Application for a non-material amendment following a grant of planning permission.
Town and Country Planning Act 1990

SINGLE STOREY FRONT AND REAR EXTENSIONS,
RAISING OF EXISTING GARAGE ROOF AS PART OF
CONVERSION OF GARAGE AND FRONT CANOPY.

AW/294/19/HH

PROPOSED AMENDMENT TO CANOPY

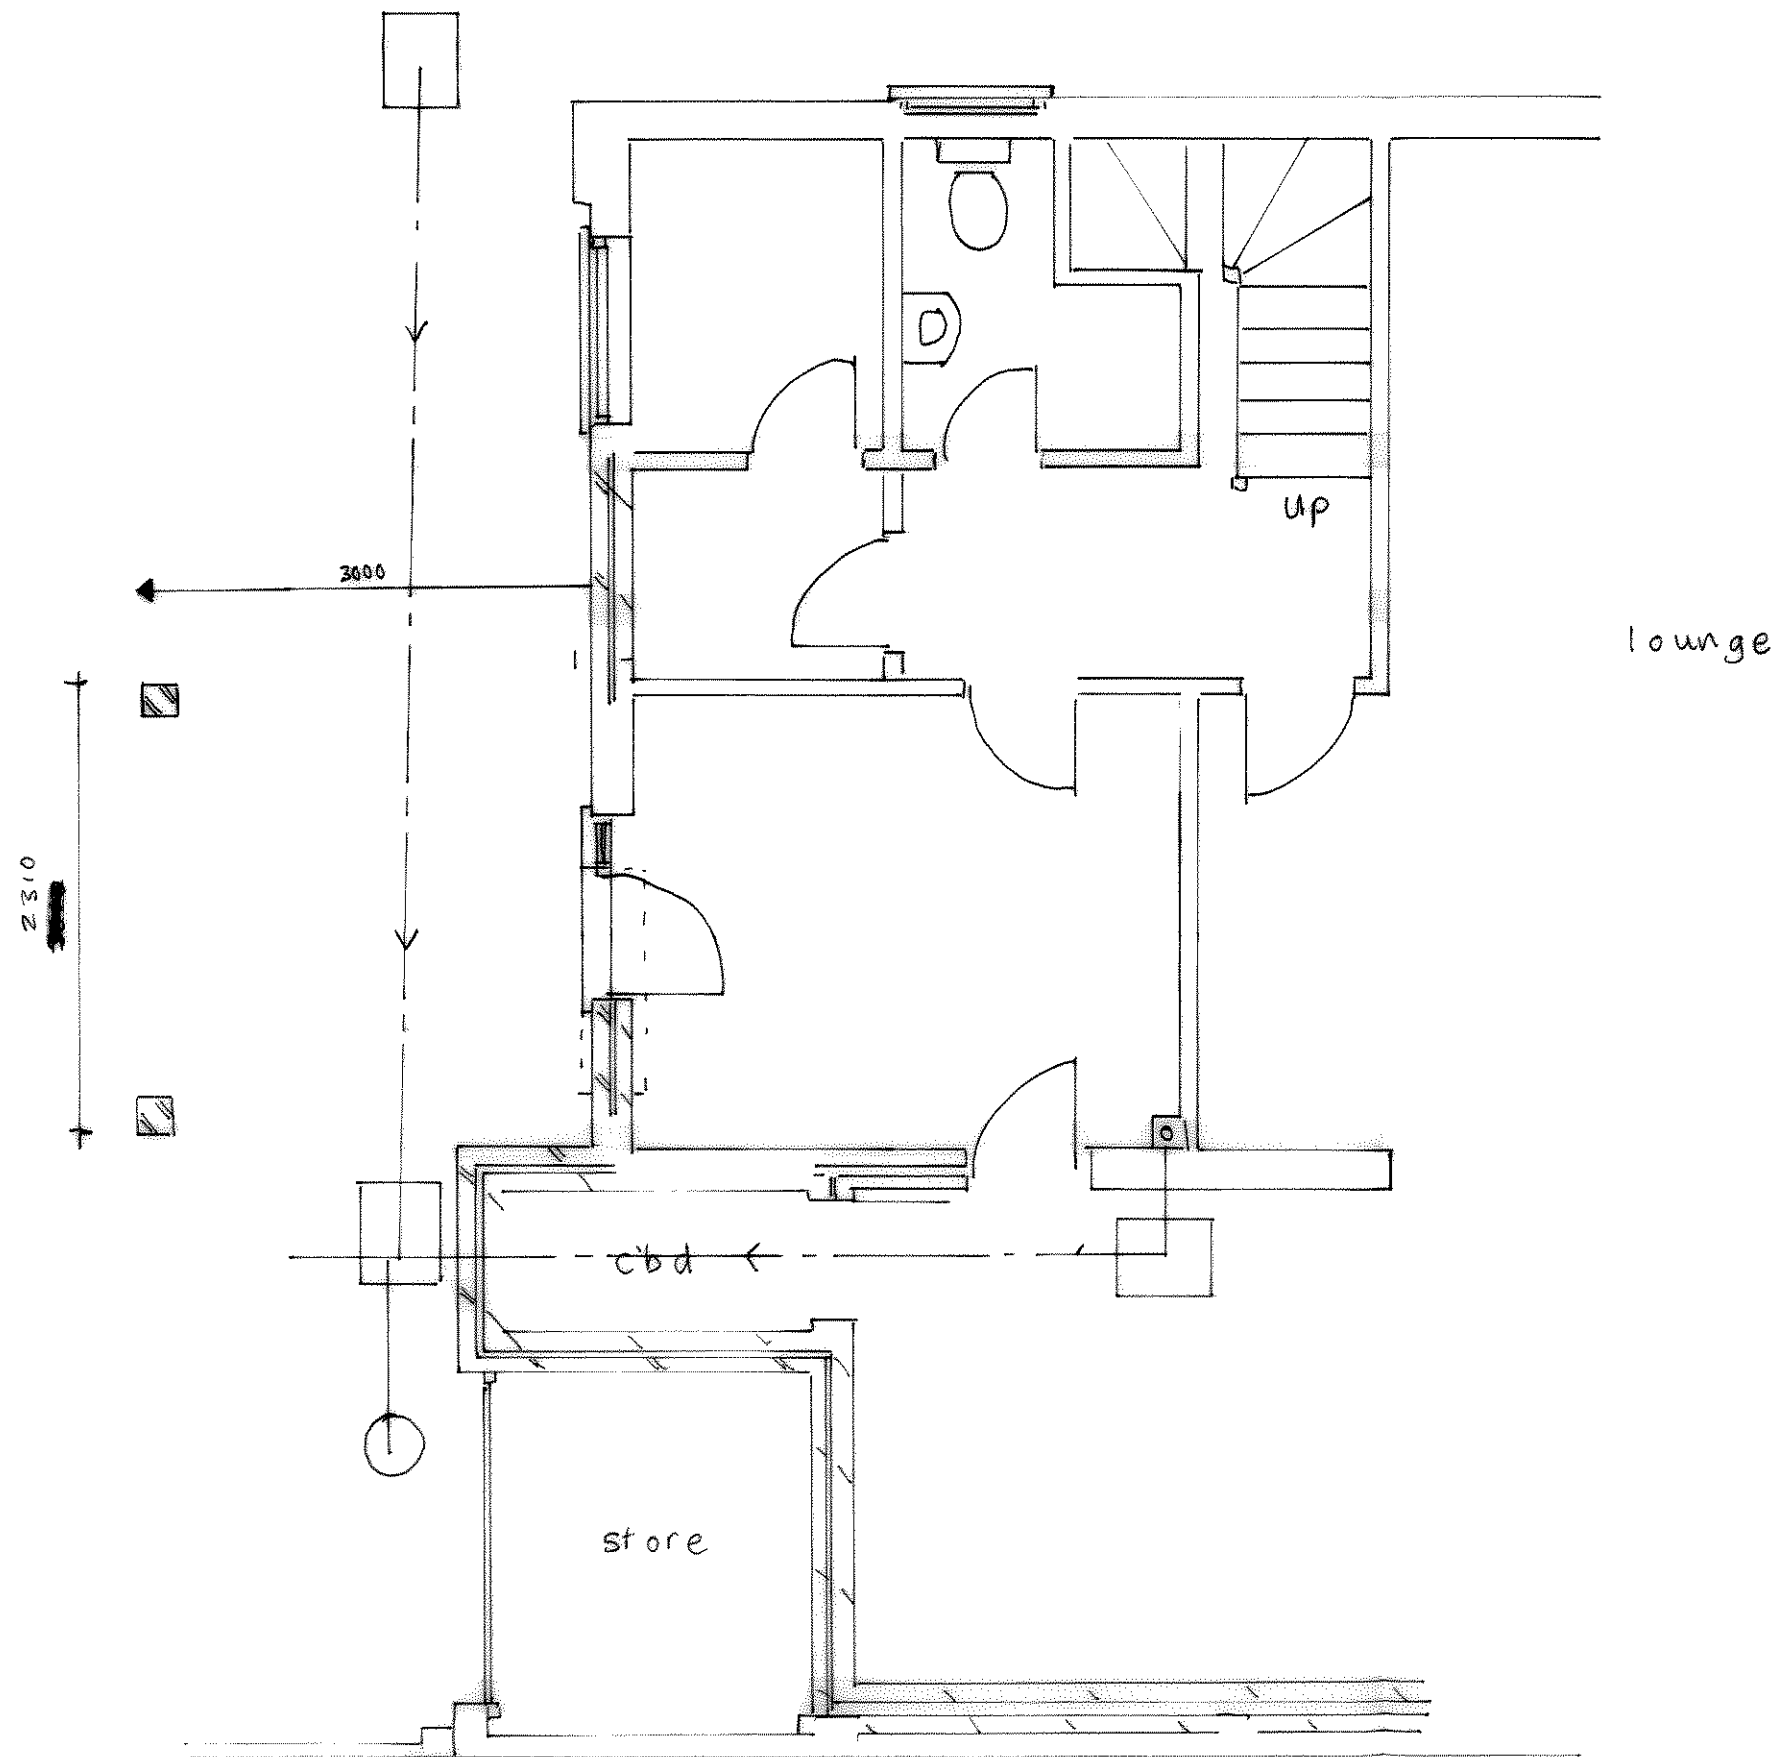
EXTENSION OF FRONT CANOPY BY ONE METRE.

TO ENABLE BETTER ACCESS
TO PROPERTY FOR DISABLED RESIDENT.
